RE: VA-22-00004 (Pemsel)

Jeremiah,
Please see my comments below regarding the setback variance application for Pemsel. Let me know if you have questions.

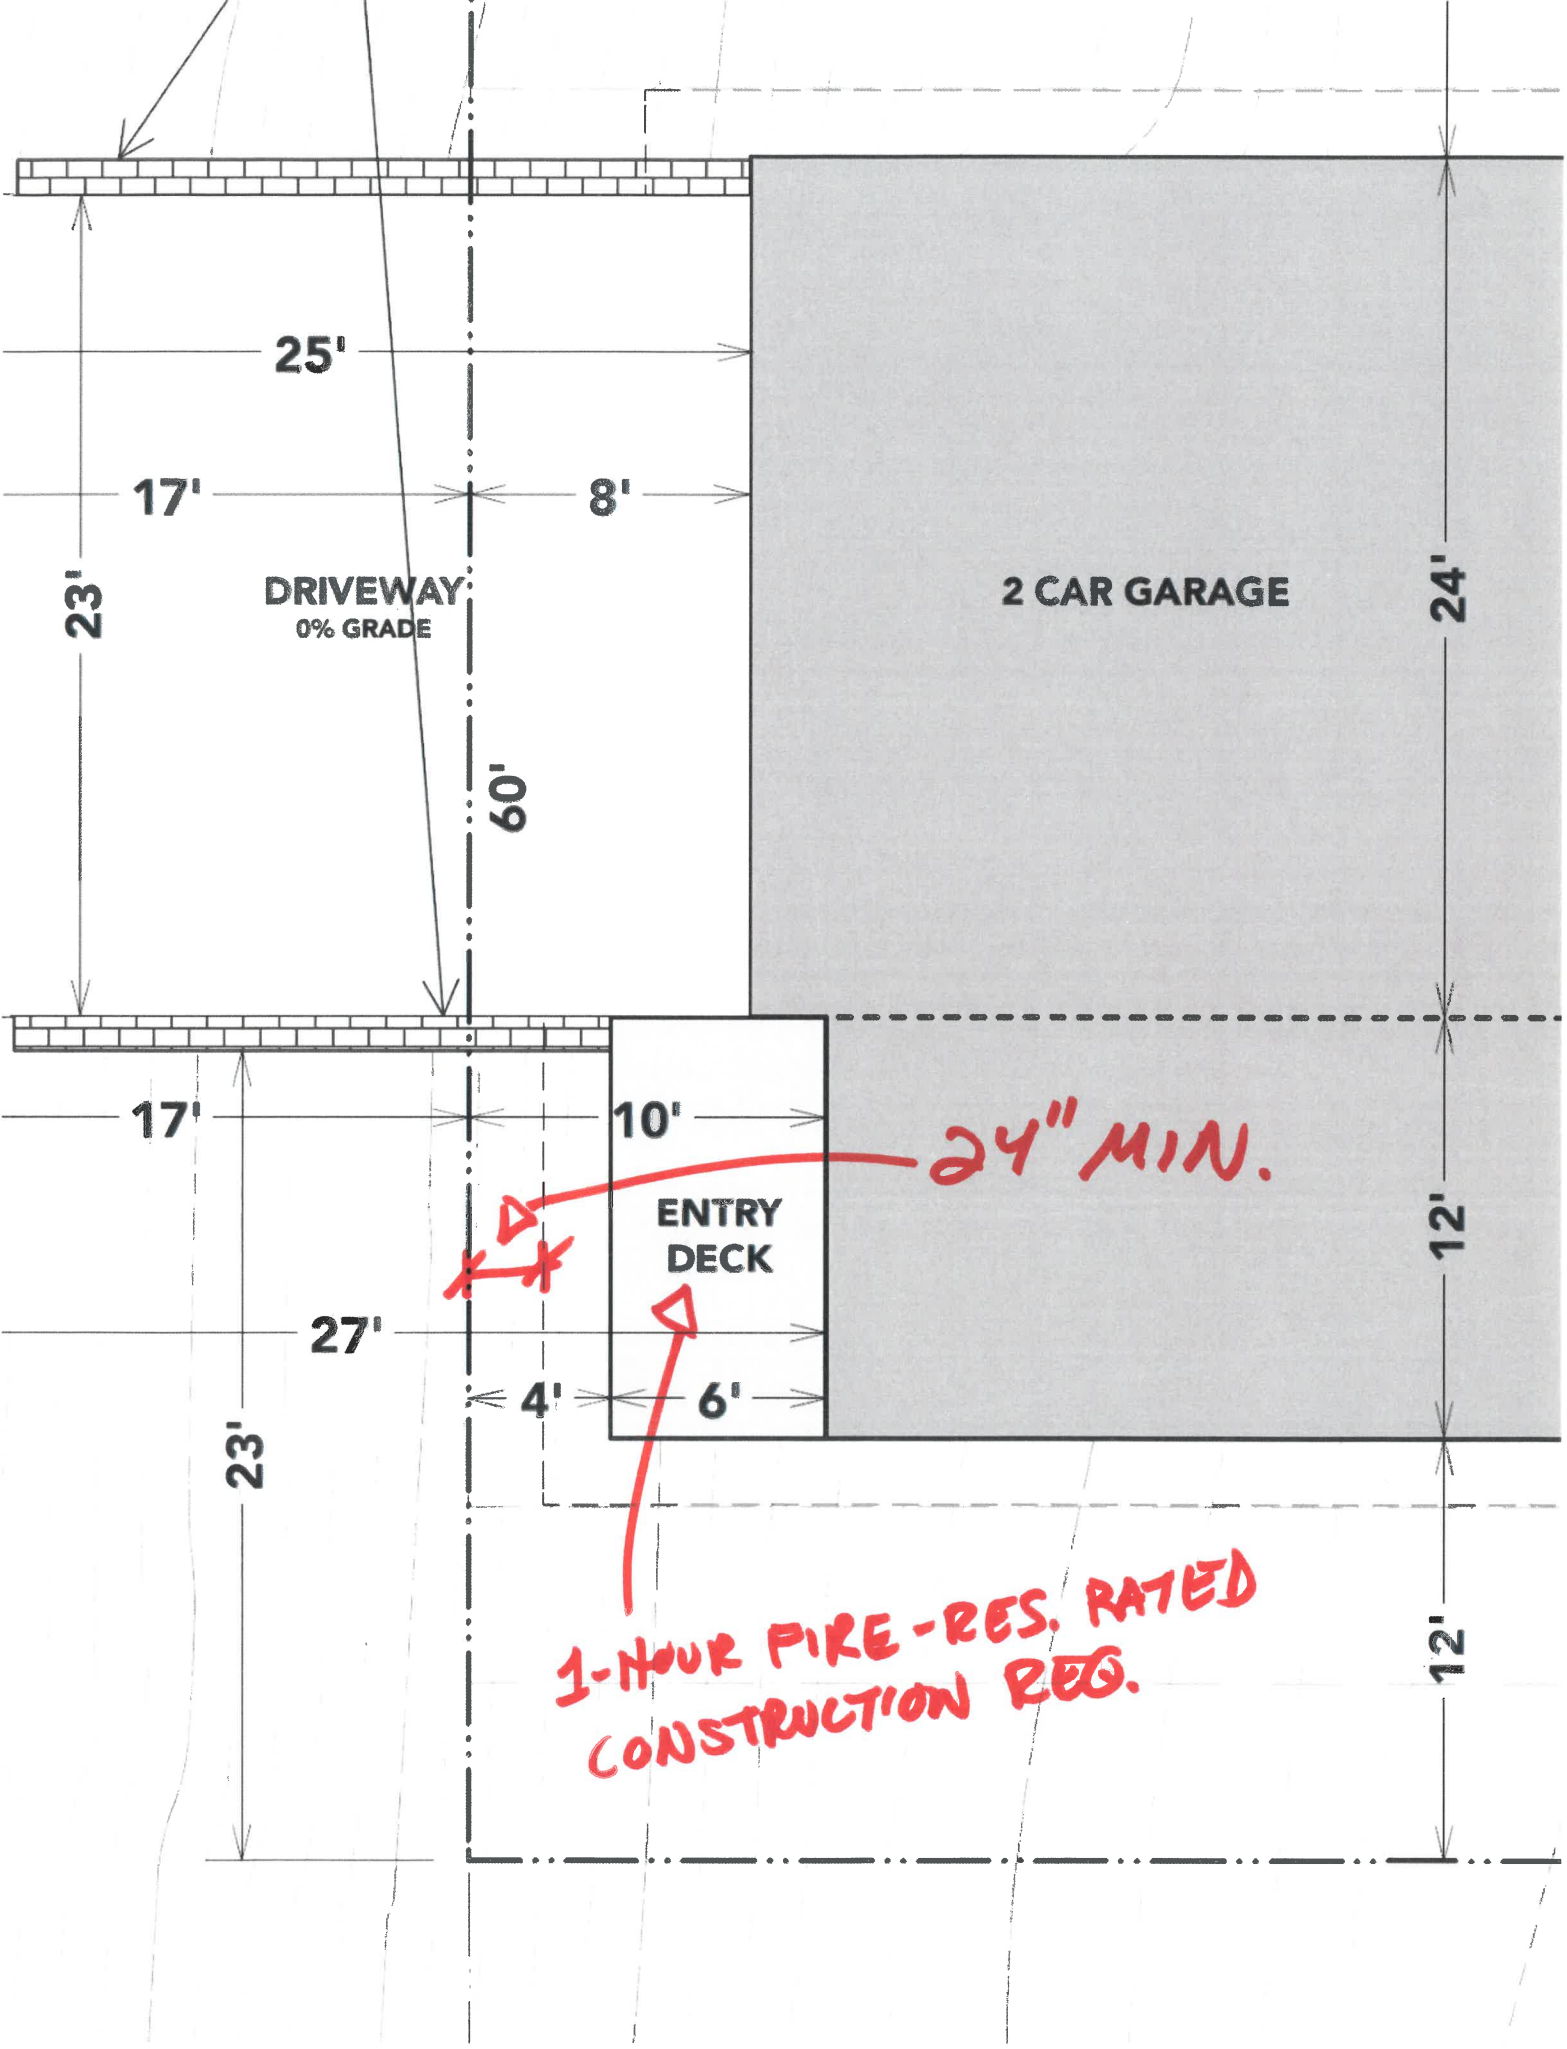
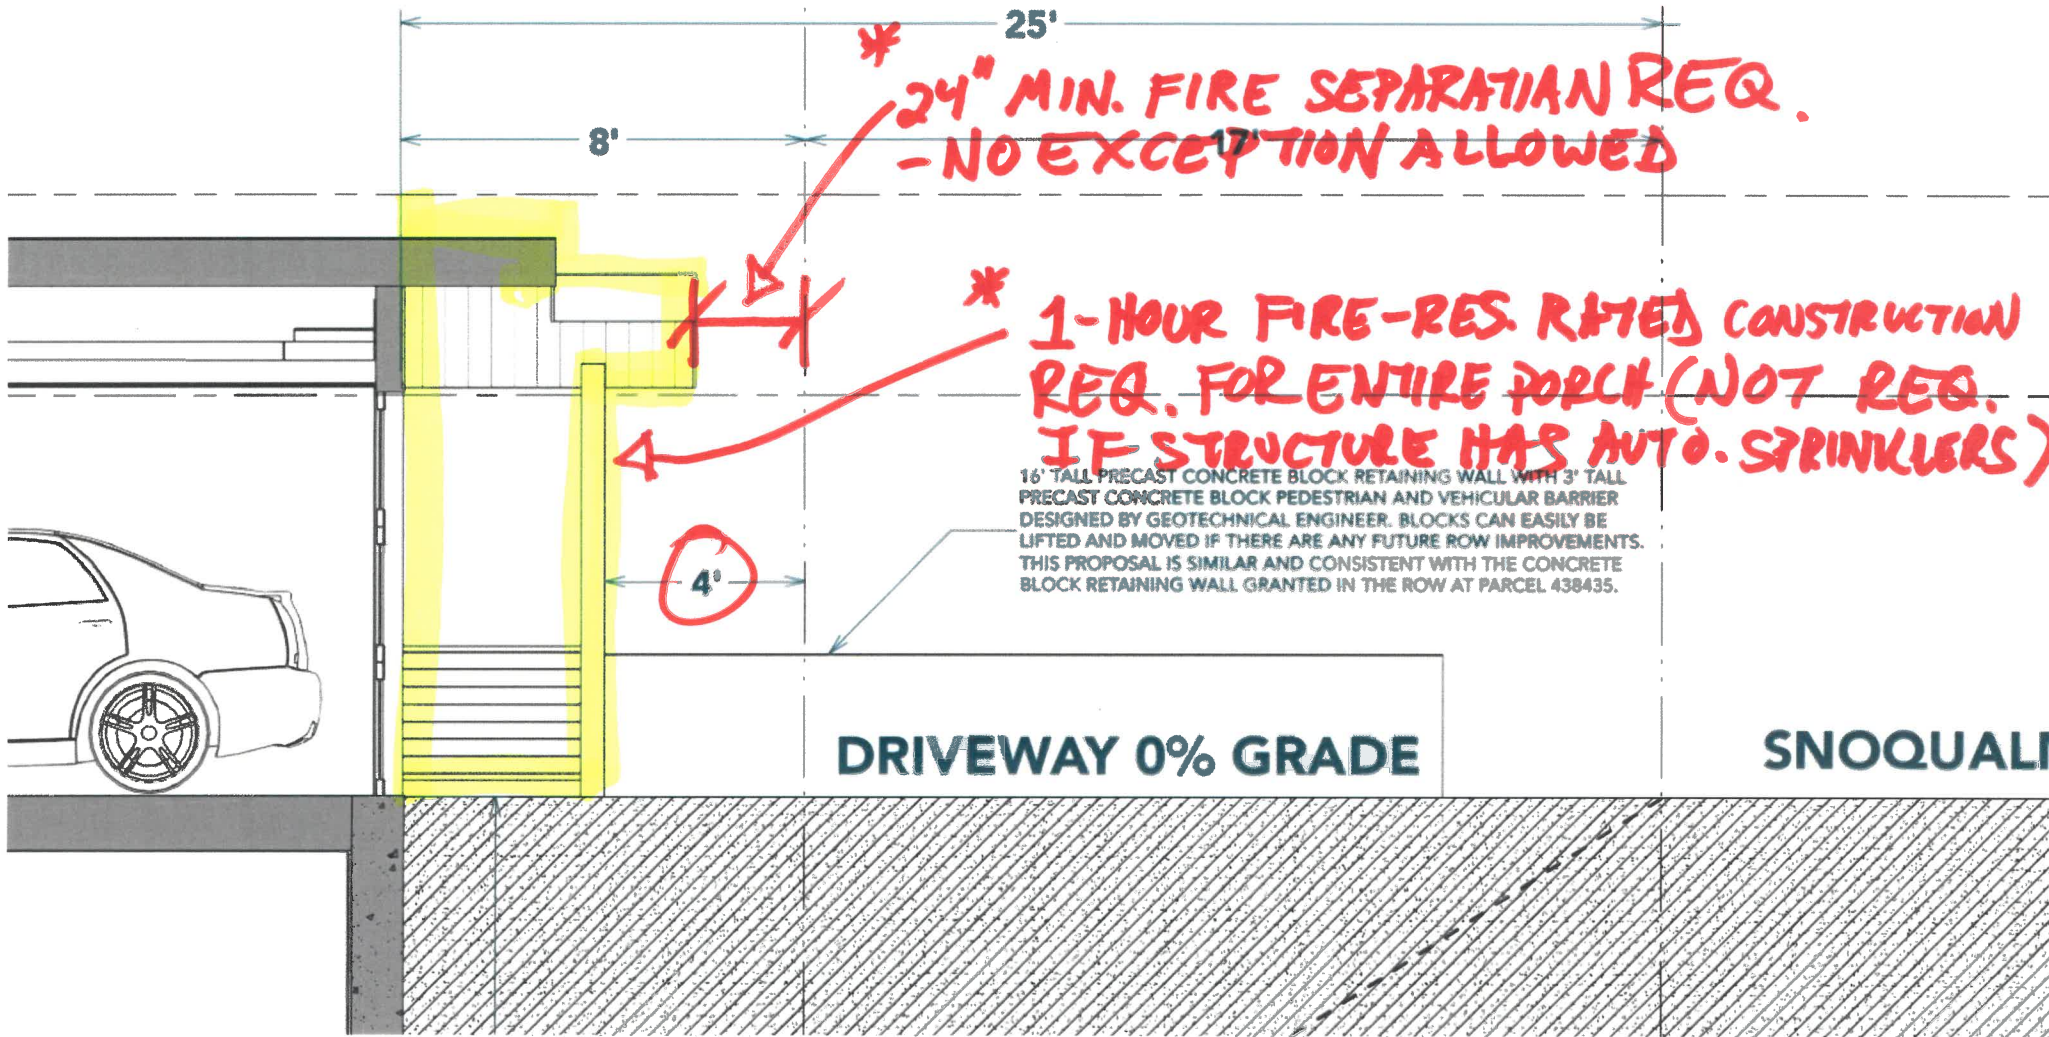
*2018 IRC Table R302.1(1) does not allow roof eaves, overhangs or any projections closer than 24 inches to a lot line.

*Exterior walls and projections located less than five (5) feet from a lot line must be one-hour fire-resistant rated. If the structure is provided with automatic sprinklers, walls and projections less than three (3) feet from a lot line must be one-hour fire-resistant rated.

* 24" MIN. FIRE SEPARATION REQ.
- NO EXCEPTION ALLOWED

* 1-HOUR FIRE-RES. RATED CONSTRUCTION
REQ. FOR ENTIRE PORCH (NOT REQ. IF STRUCTURE HAS AUTO. SPRINKLERS)

1-HOUR FIRE-RES. RATED
CONSTRUCTION REQ.
